Subject: Rucker Boundary Line Adjustment (BL-15-00005)

On May 22, 2015 Kittitas County Community Development Services (CDS) received your application for the above Boundary Line adjustment Permit (BL-15-00005). The application as submitted has been deemed **incomplete** by CDS until such time as the following are submitted:

**RECORD OF SURVEY**  
 A PORTION OF THE SE 1/4 OF SECTION 30,  
 TOWNSHIP 20 NORTH, RANGE 17 EAST, W.M.,  
 KITITAS COUNTY, WASHINGTON

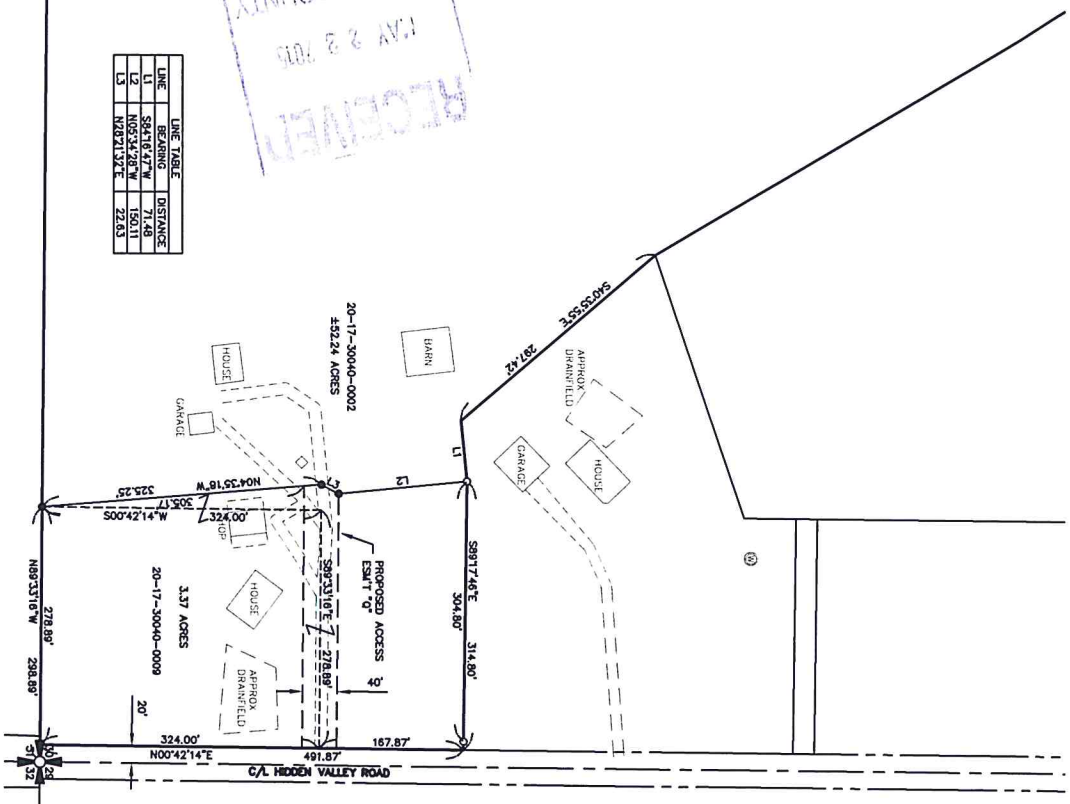
- *Scaled site plan encompassing all parcels involved in the boundary line adjustment. You have submitted a site plan with all of parcel 20-17-30040-0009 and part of parcel 20-17-30040-0002.*
